PLANNING AND COMMUNITY DEVELOPMENT DEPARTMENT  
CRAIG DOSSEY, EXECUTIVE DIRECTOR

County File: OAR-20-019

Re: Aspen Ranch Preliminary Plat

UT01

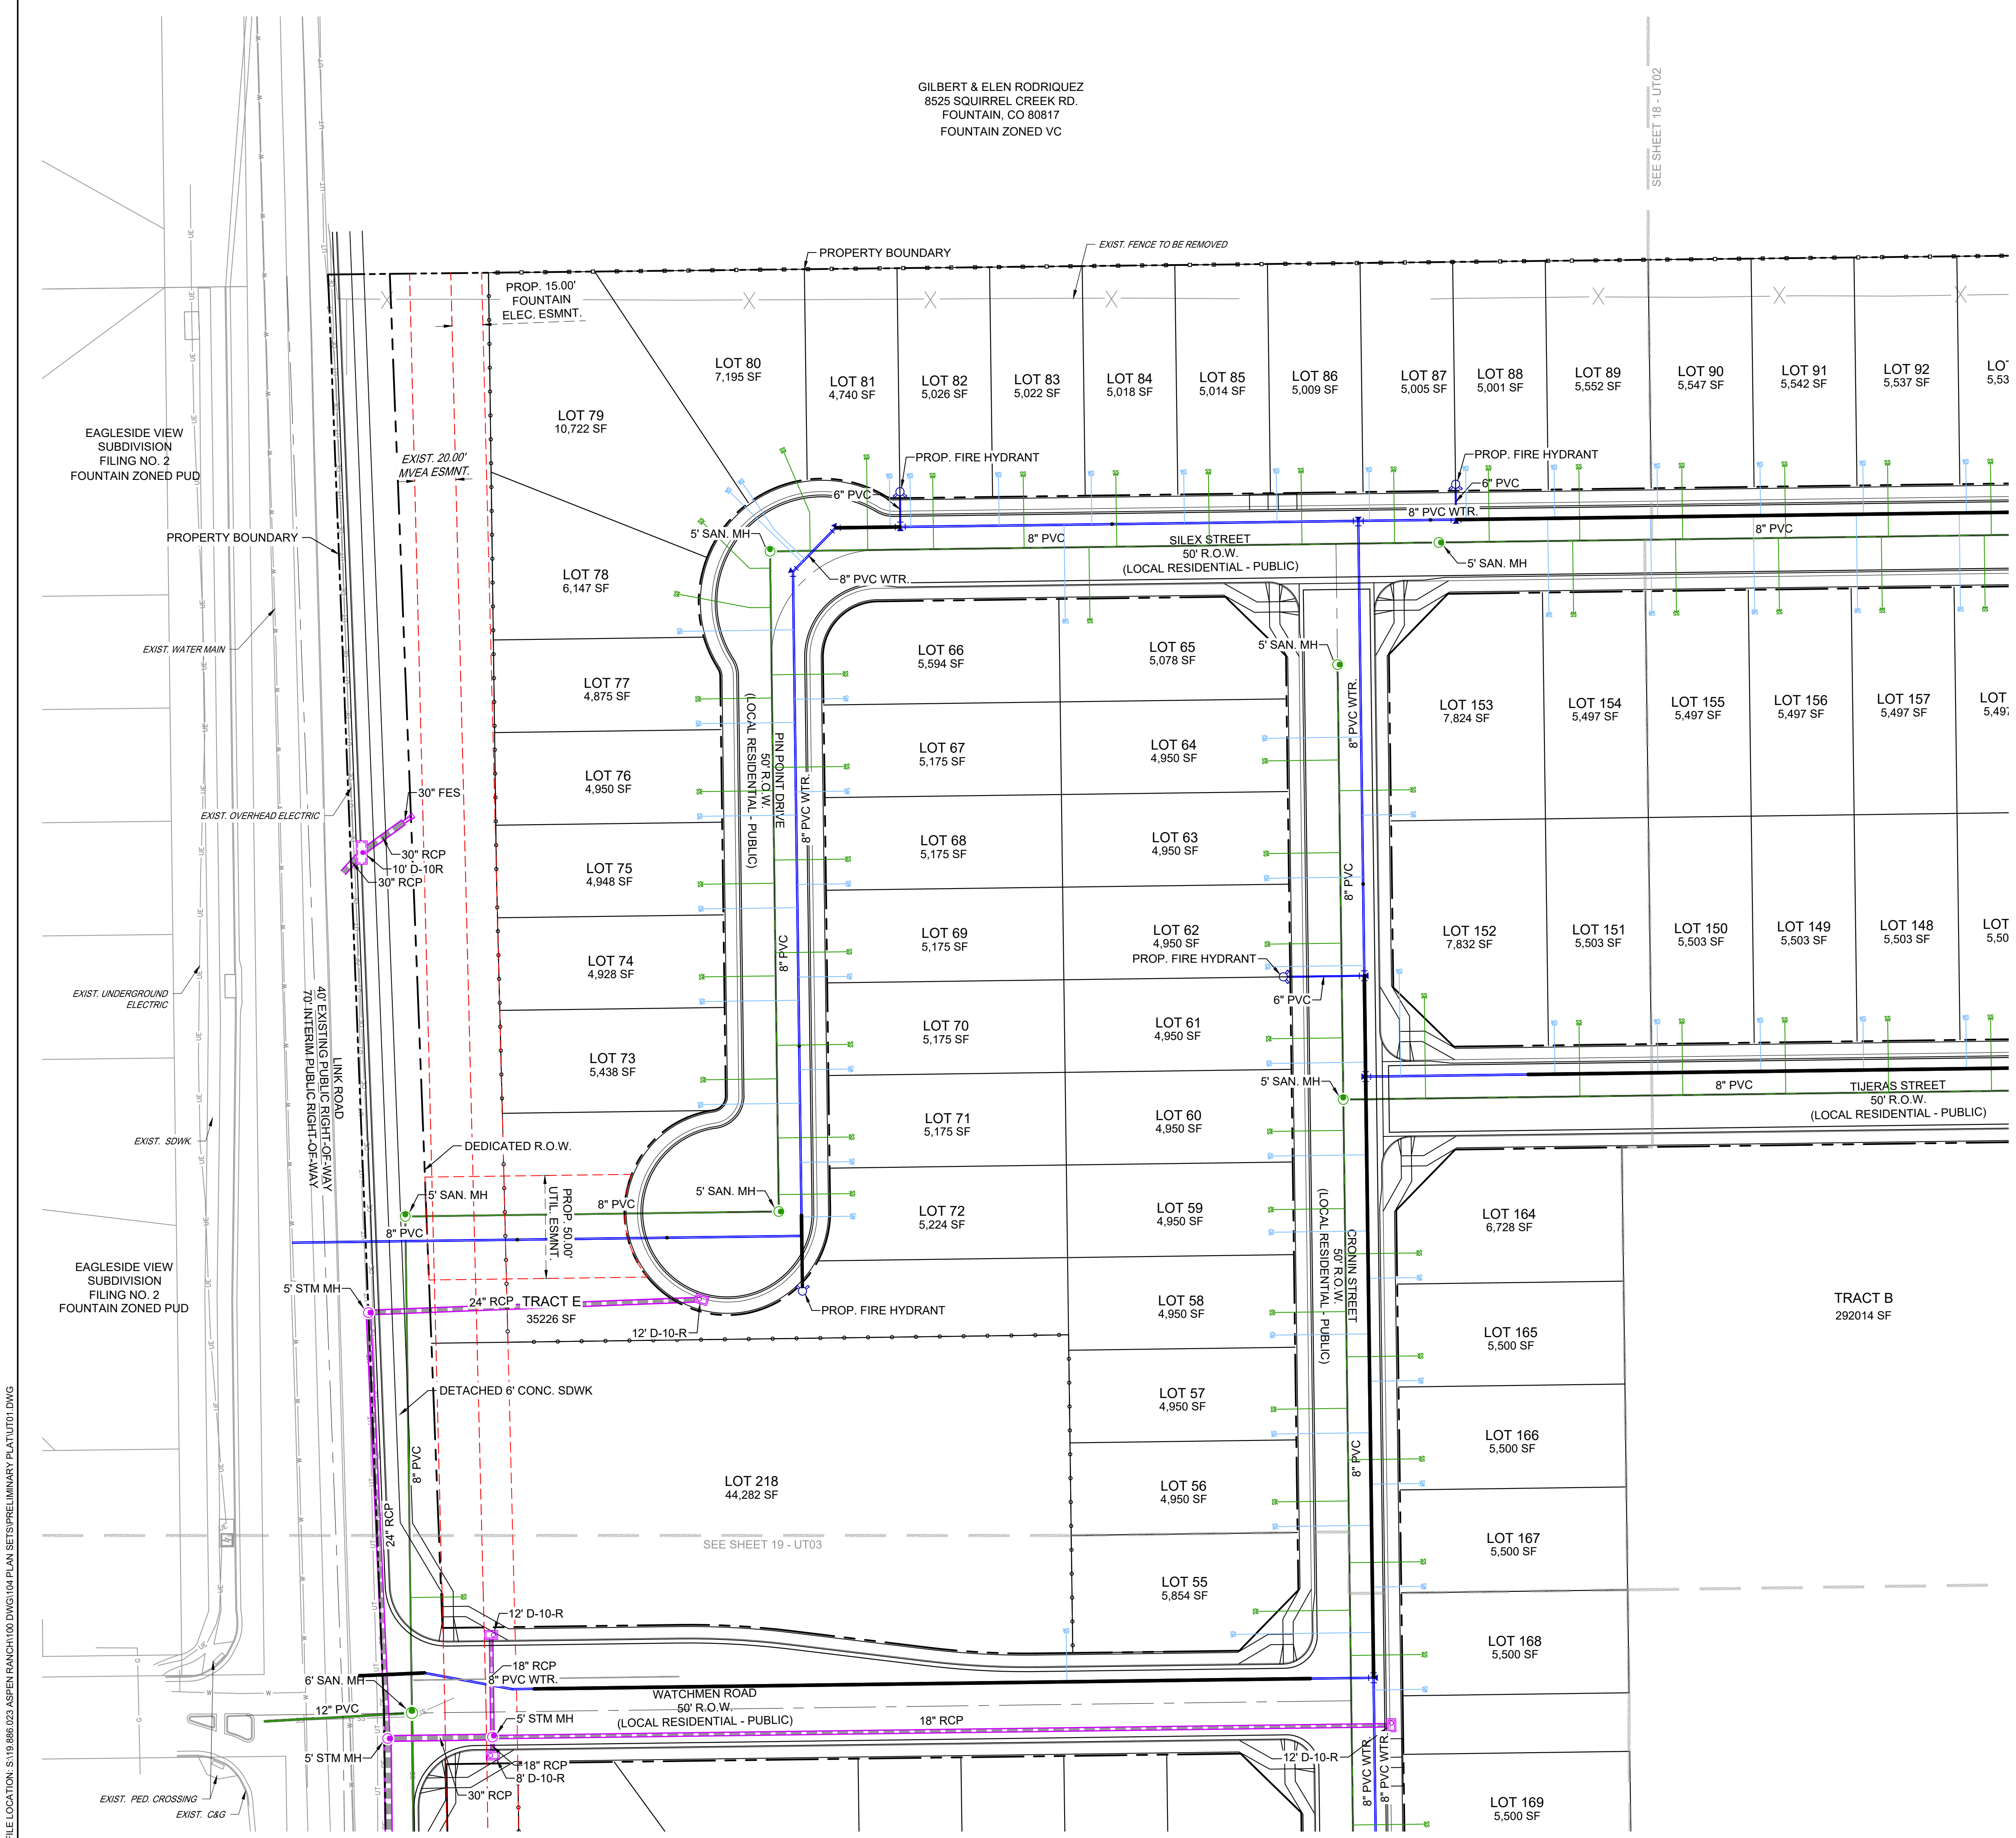
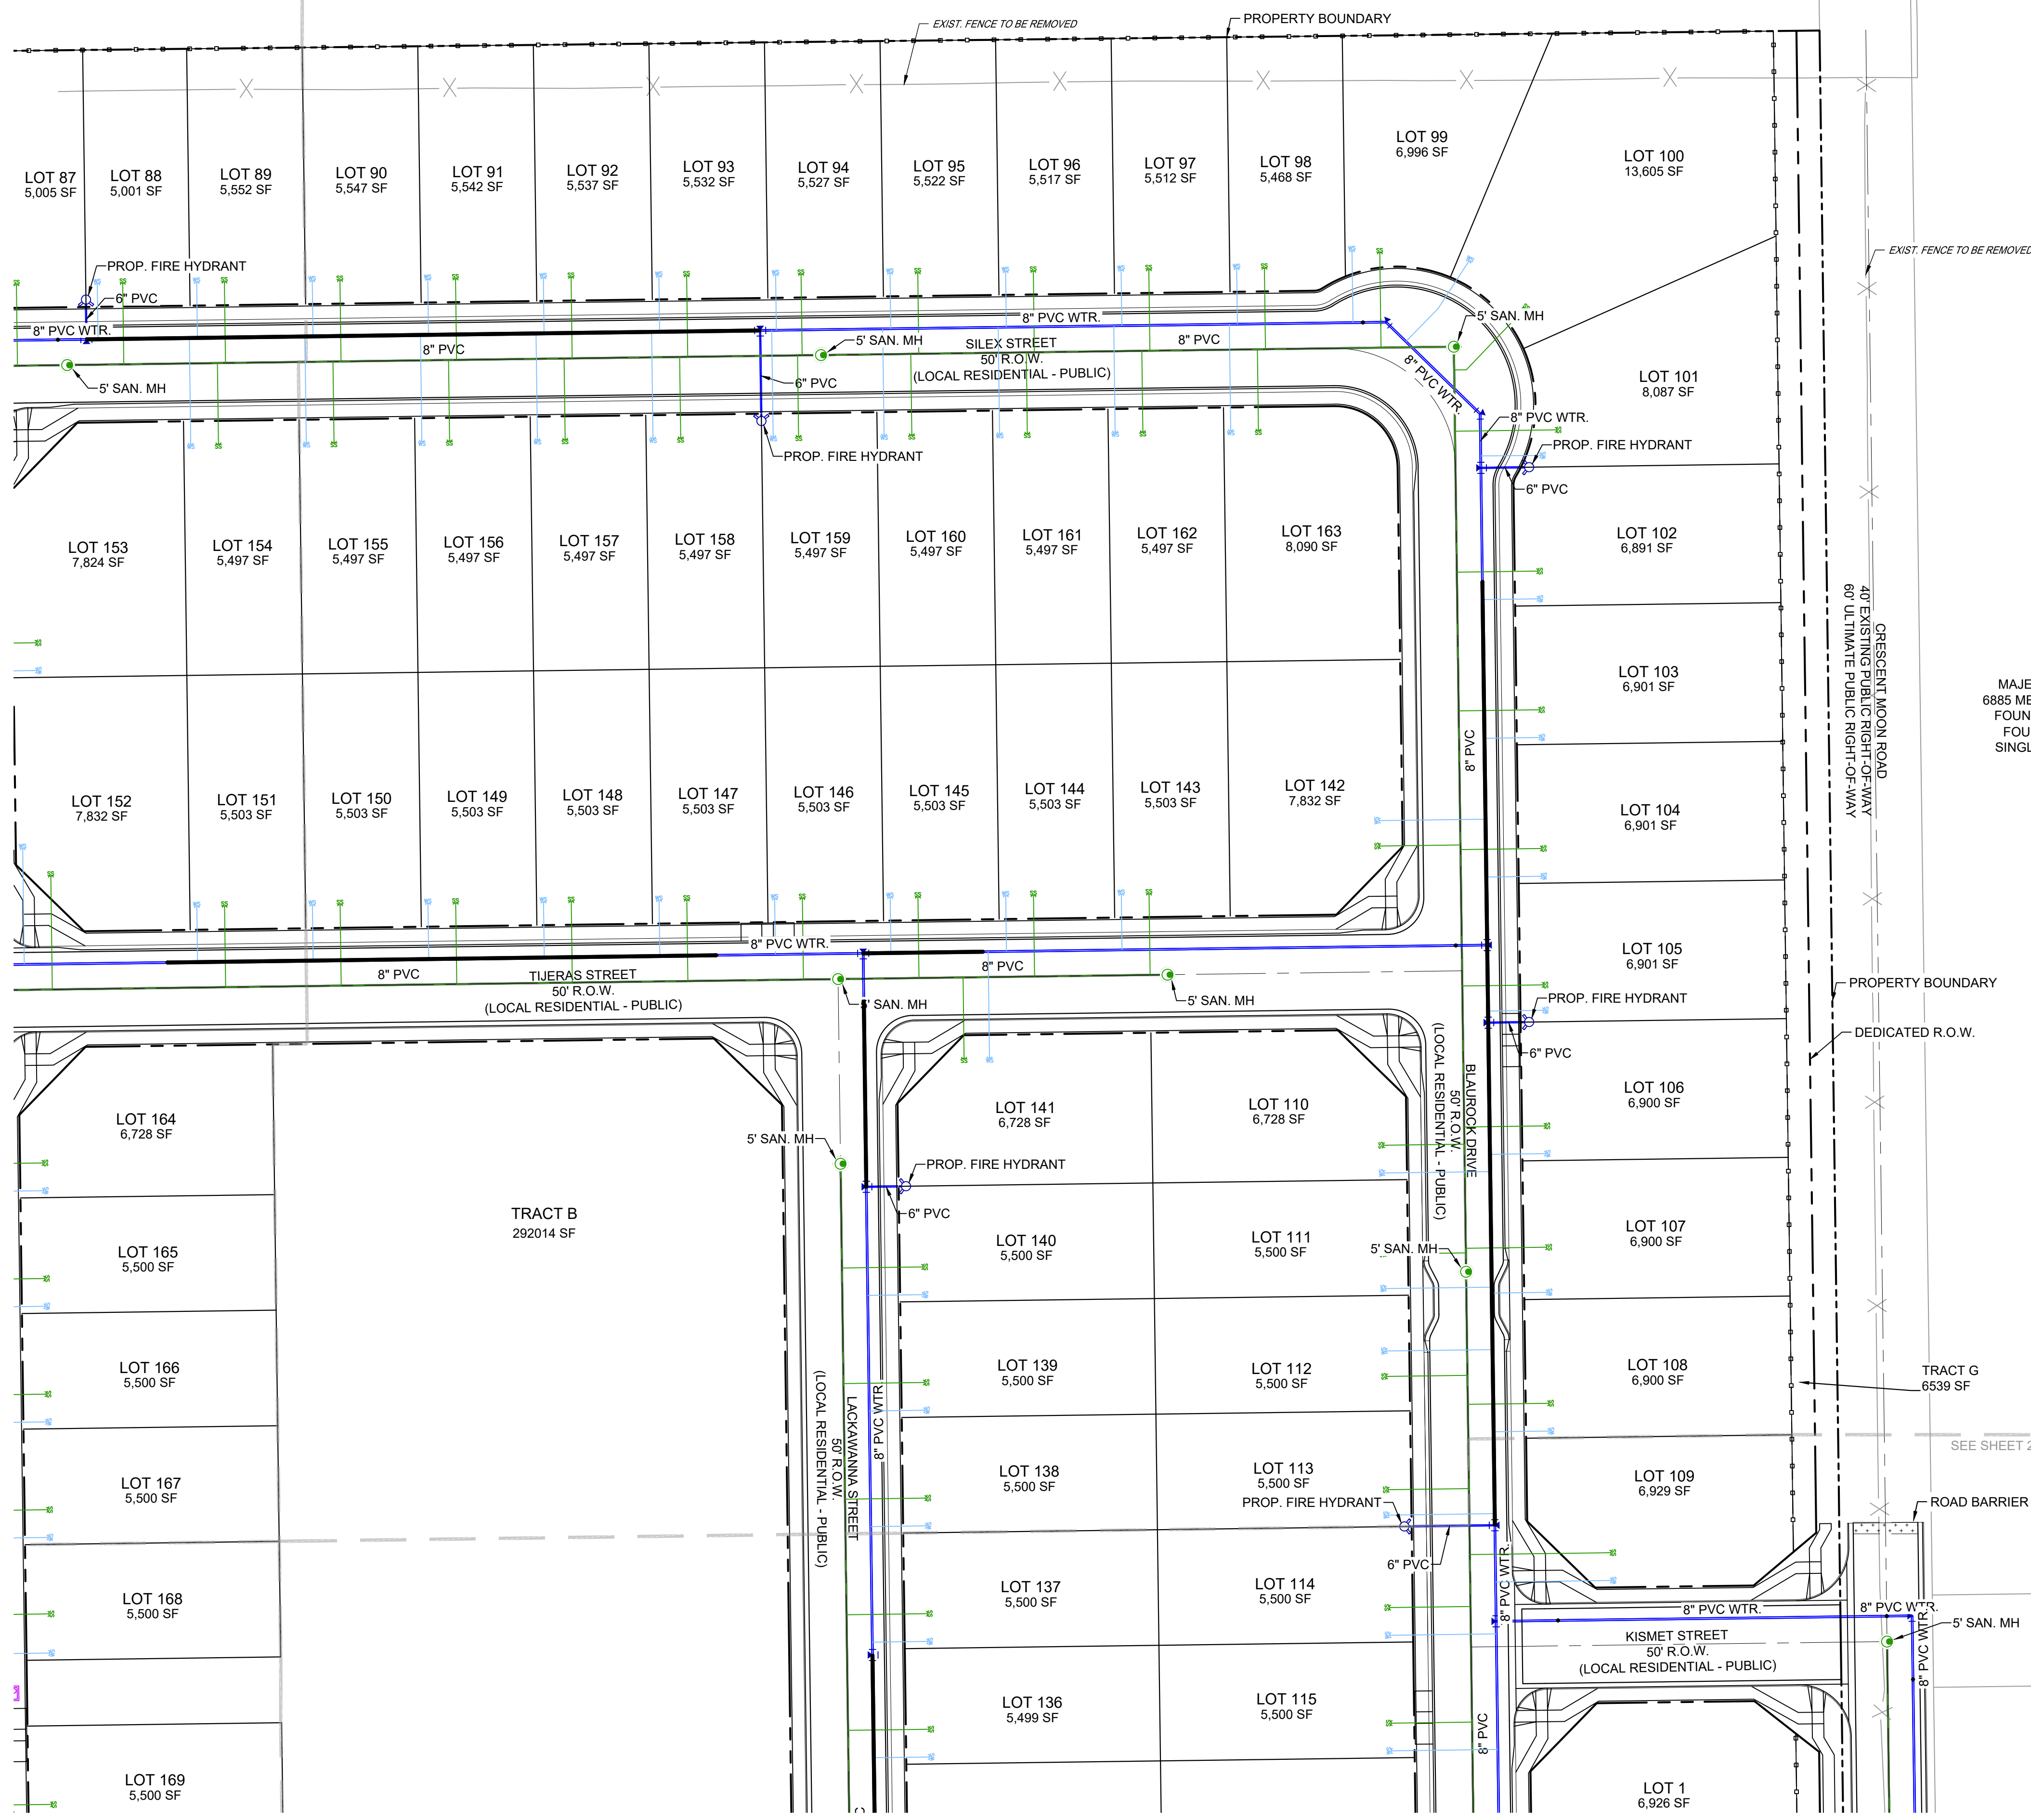
1. Provide a copy of the traffic impact study. The public roads in the immediate vicinity are owned/maintained by the City of Fountain.
2. Provide a copy of the drainage report for review. Based on the preliminary utility, the detention pond outfall across Link Road into a private property within the County. Additionally, runoff east of the development is routed around the proposed development and outfalls at the same location. Drainage report shall provide analysis of the offsite channel for hydraulic adequacy and provide conclusion/recommendation.
